Response to Planning Application

Application ref: Y/152/20/RES

Description: Approval of reserved matters (appearance, landscaping, layout and scale) following the grant of Y/91/17/OUT for 250 No. dwellings with associated parking, road/footway/ cycleway provision, open space, landscaping, surface water attenuation & ancillary works.

Location: Land at Bilsham Road Yapton

drawing title
General Arrangement Plan

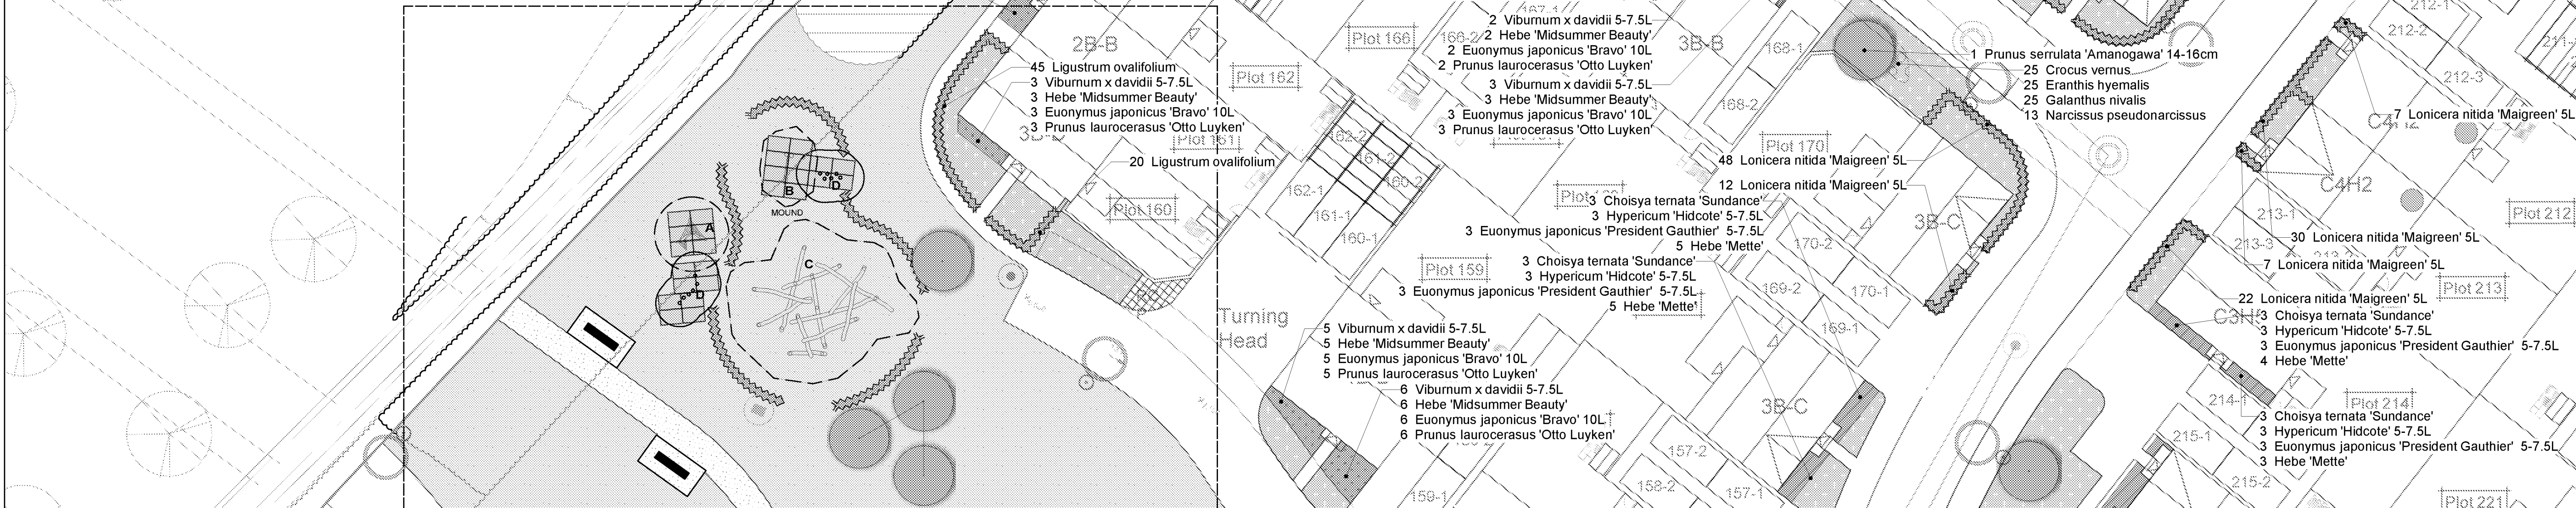
Following submission of, Detailed Landscape proposal sheets 101B – 110B, Play spaces sheet 111B and General Arrangement plan 100B, I confirm that the information submitted has provided a well thought out Landscape scheme which is fitting for location providing a good mix of native and ornamental trees and shrubs with suitable planting densities and size at time of planting. The large and well-located areas of POS to the periphery of the site and within these proposals will be beneficial to the existing quality trees within this portion of the SD7 allocation. The layout of the residential areas and dwellings will have direct access to these POS areas. The green corridor surrounding and through the site has the potential to aid and enhance wildlife and biodiversity habitat.

- The SuDS features within the POS areas will need to be quantified and confirmation provided that excluding these features the quantum of usable POS still conforms to our Open Space, Playing Pitches, Indoor and Built Sports Facilities SPD, Jan 2020.
- The large POS area has a pathway which is shown as Hoggin formation. Yapton Parish Council have previously asked for path and cycleways throughout the site and across the POS areas to be DDA compliant and of Tarmac finish in order to allow year round high trafficked access. Accessibility within and beyond the proposals and to PROWs should be promoted and recommended that all routes within the application site should be dual use (pedestrian and cyclists) with confirmation of width and surfacing in accordance with WSCC criteria.

7905-L-110

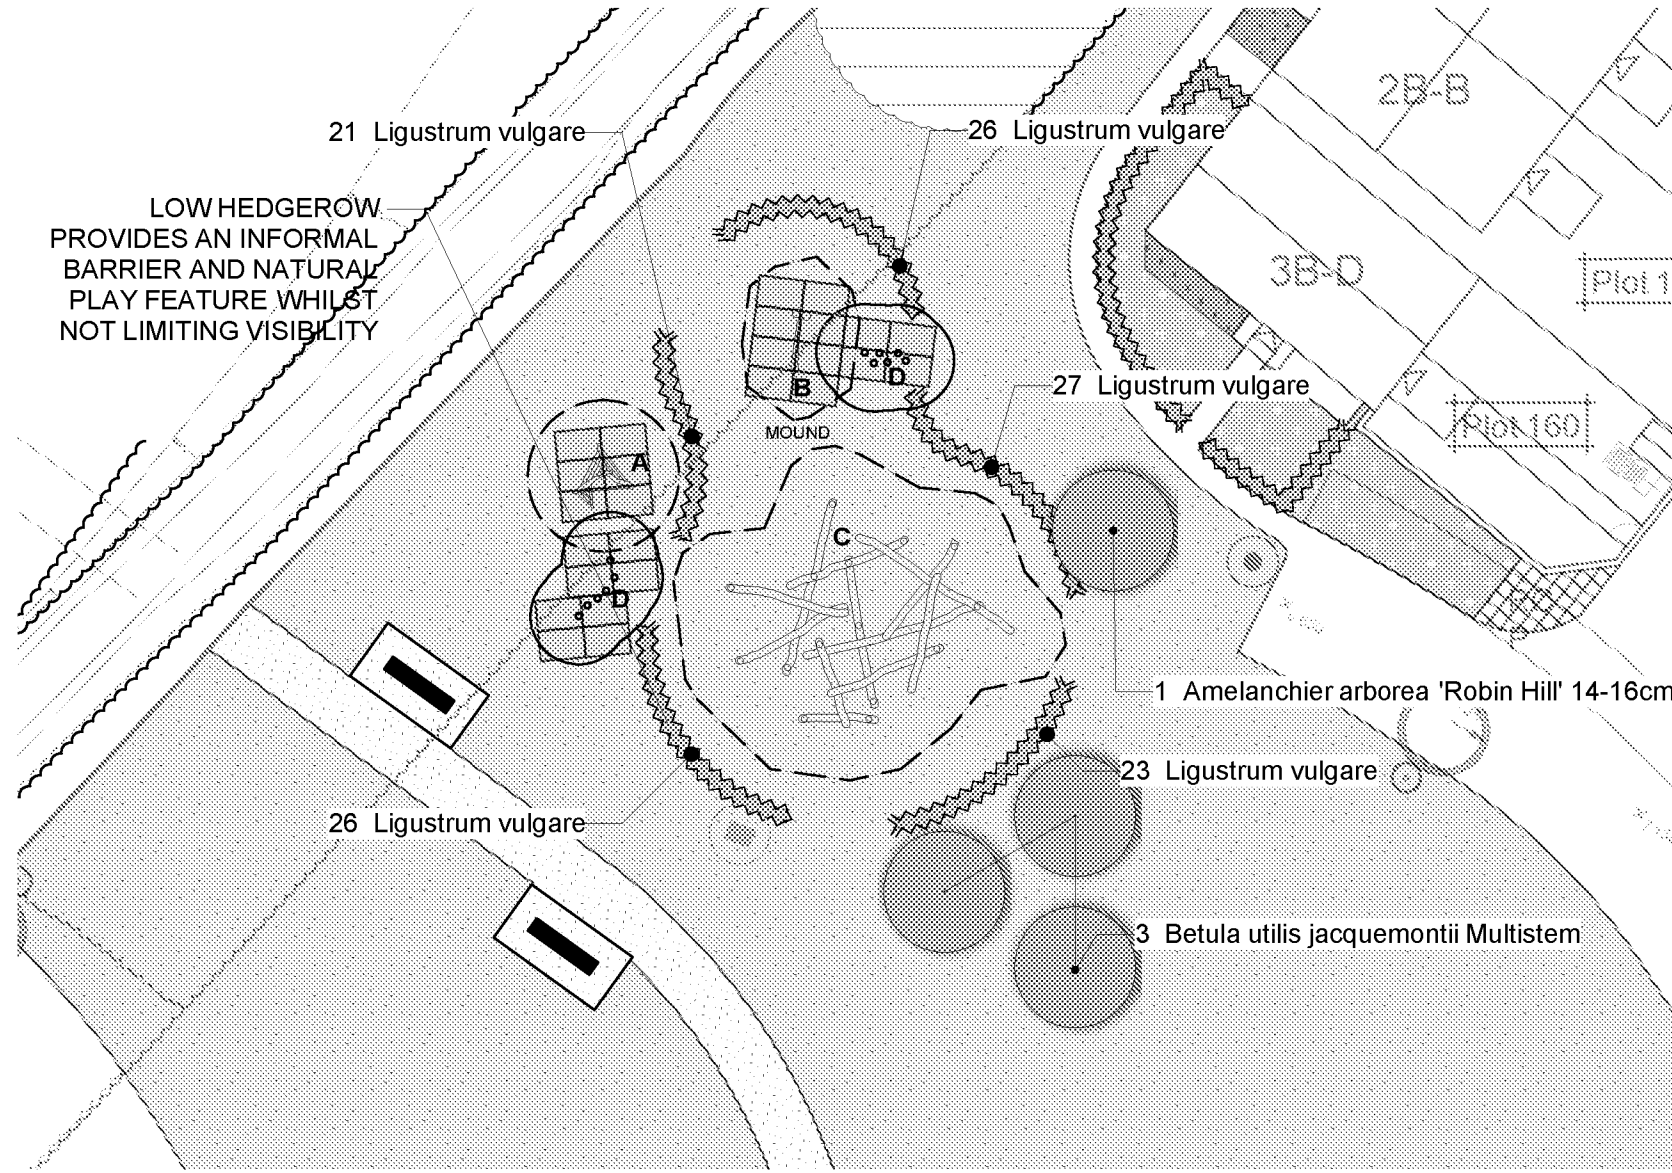
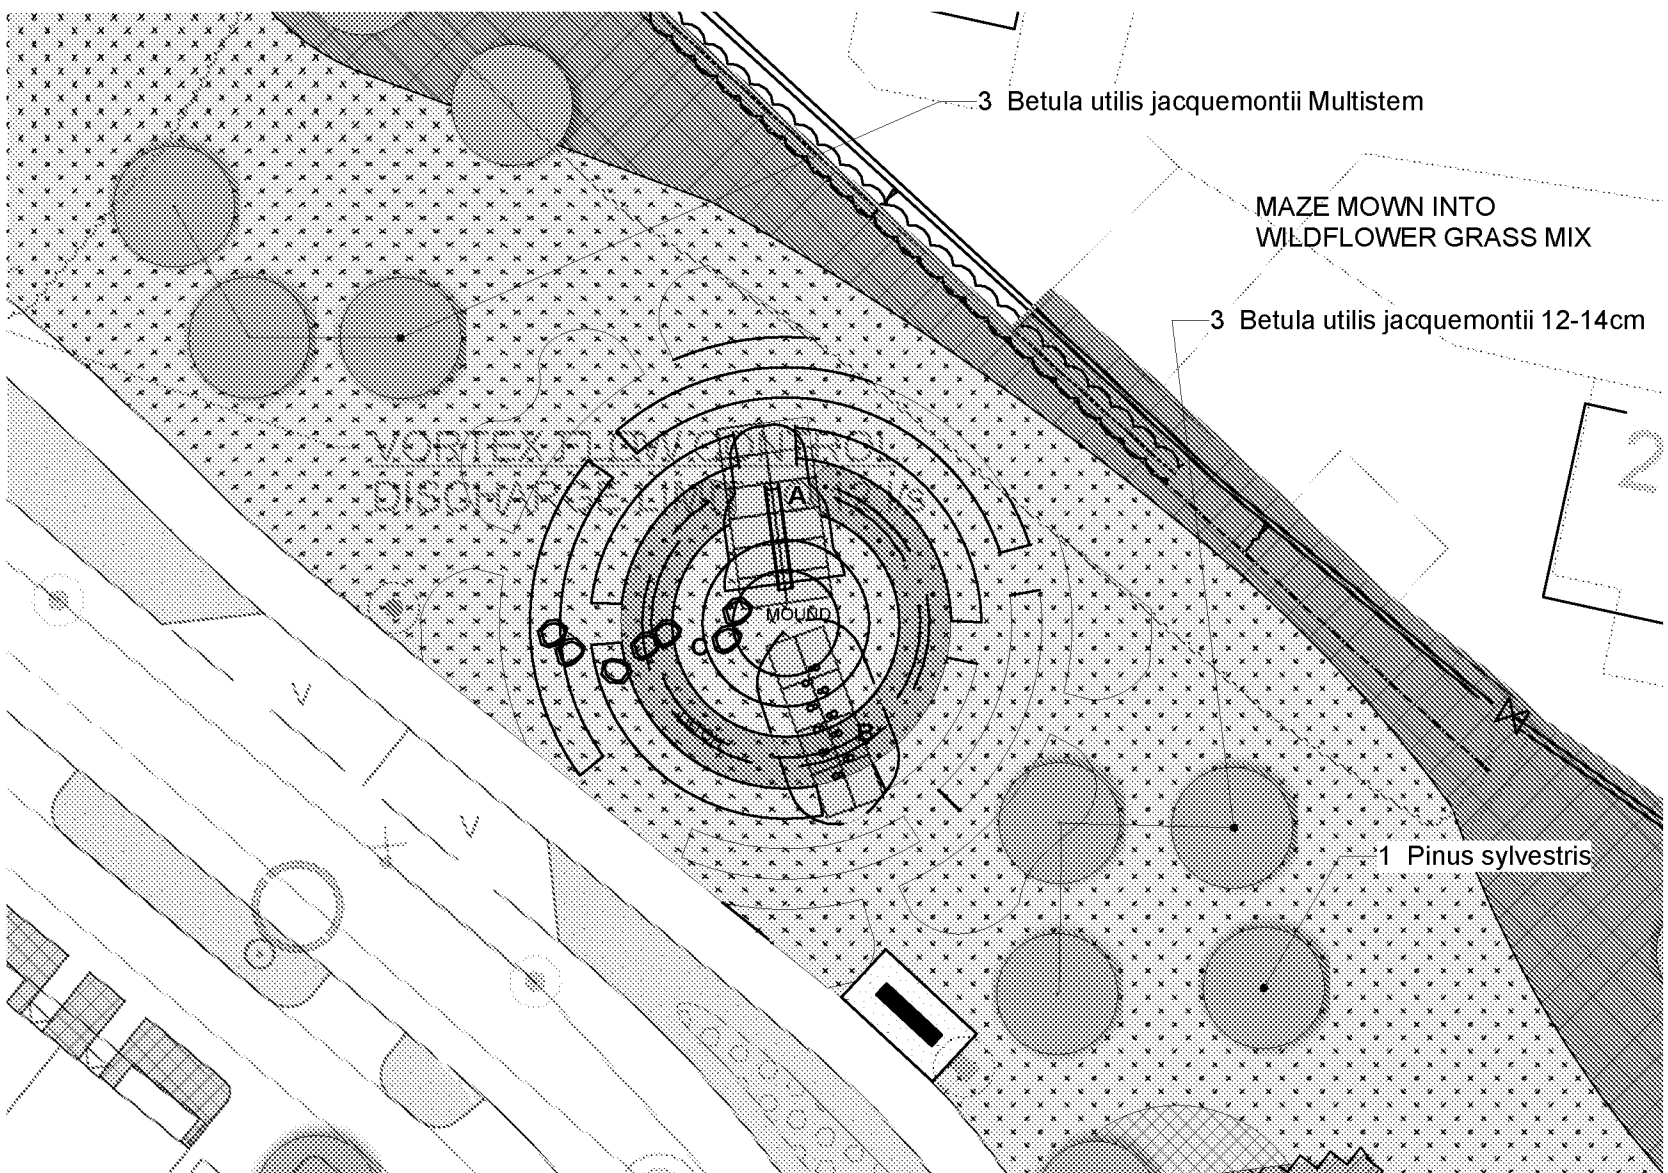
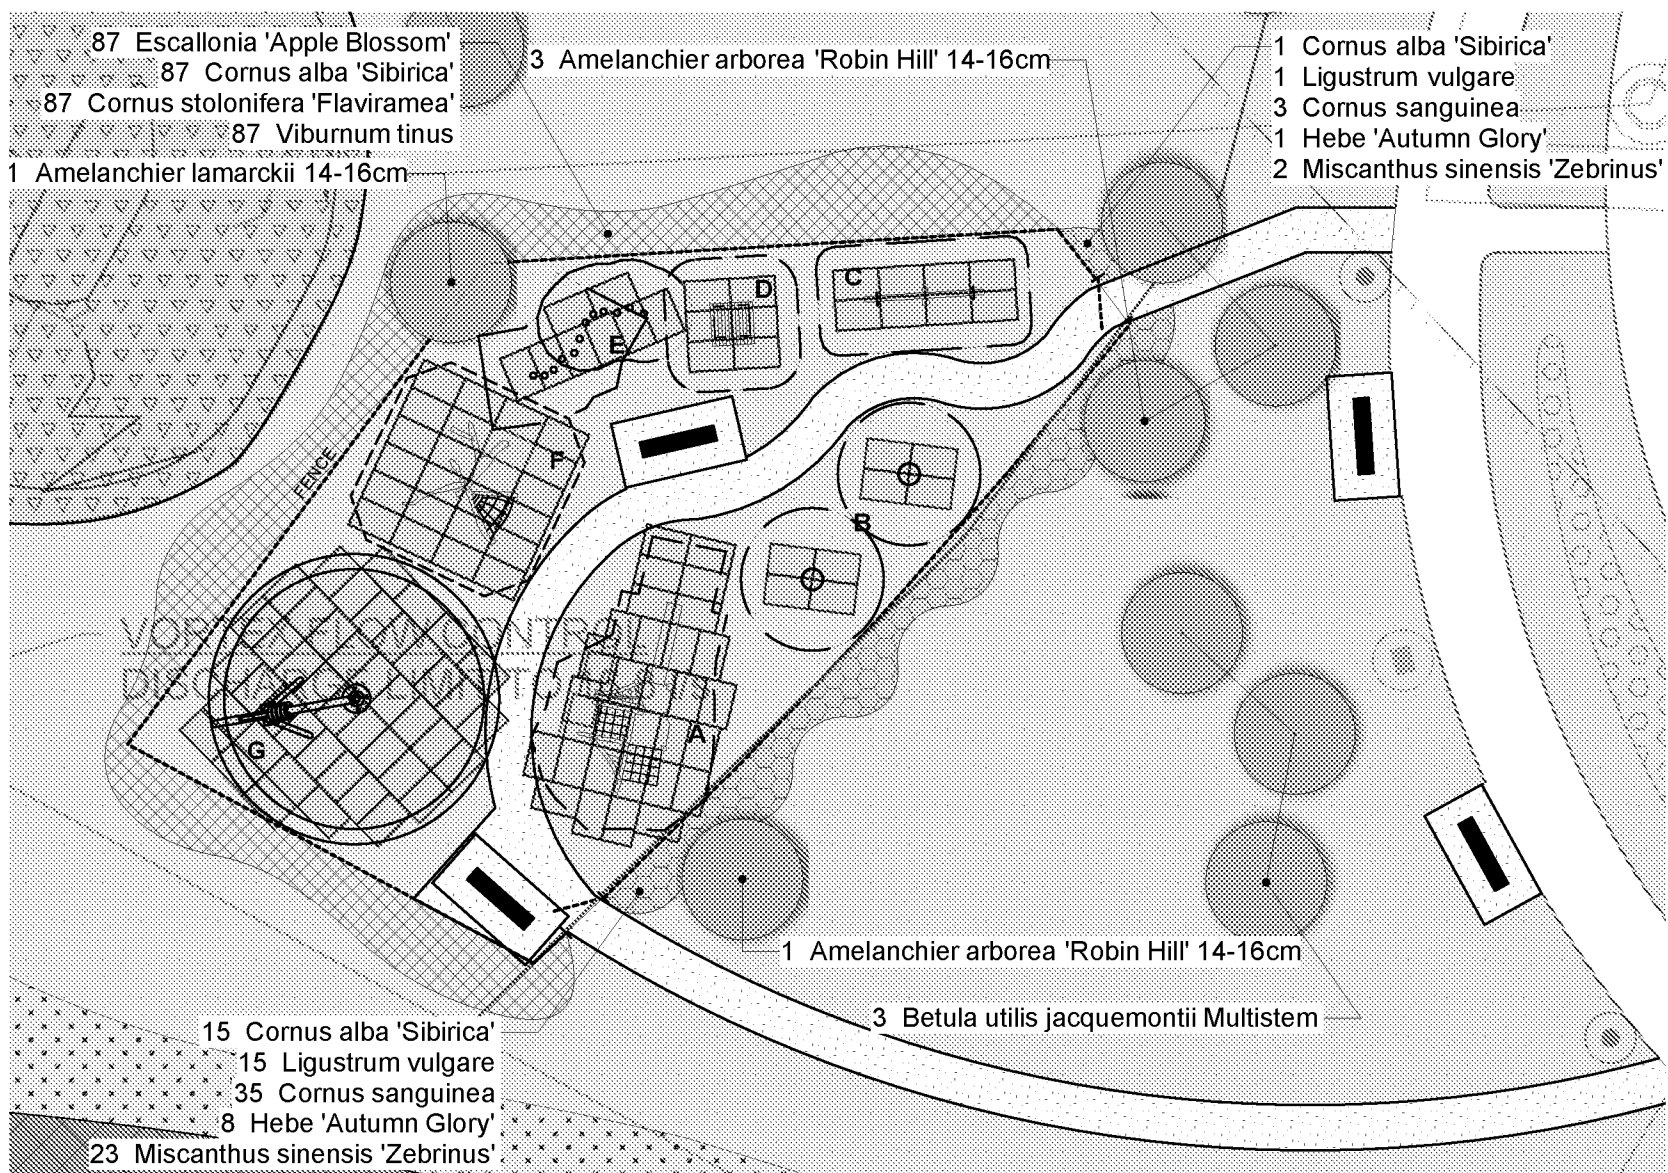
The Landscape proposals Play Spaces dwg Sheet 11 111B has provided detail of 2no LAP and 1no LEAP area. These details have proposed a scheme which will provide a variety of formal and informal play with a good mix of play experience. These areas have included suitable connectivity and pathway access with appropriate safety surfacing.
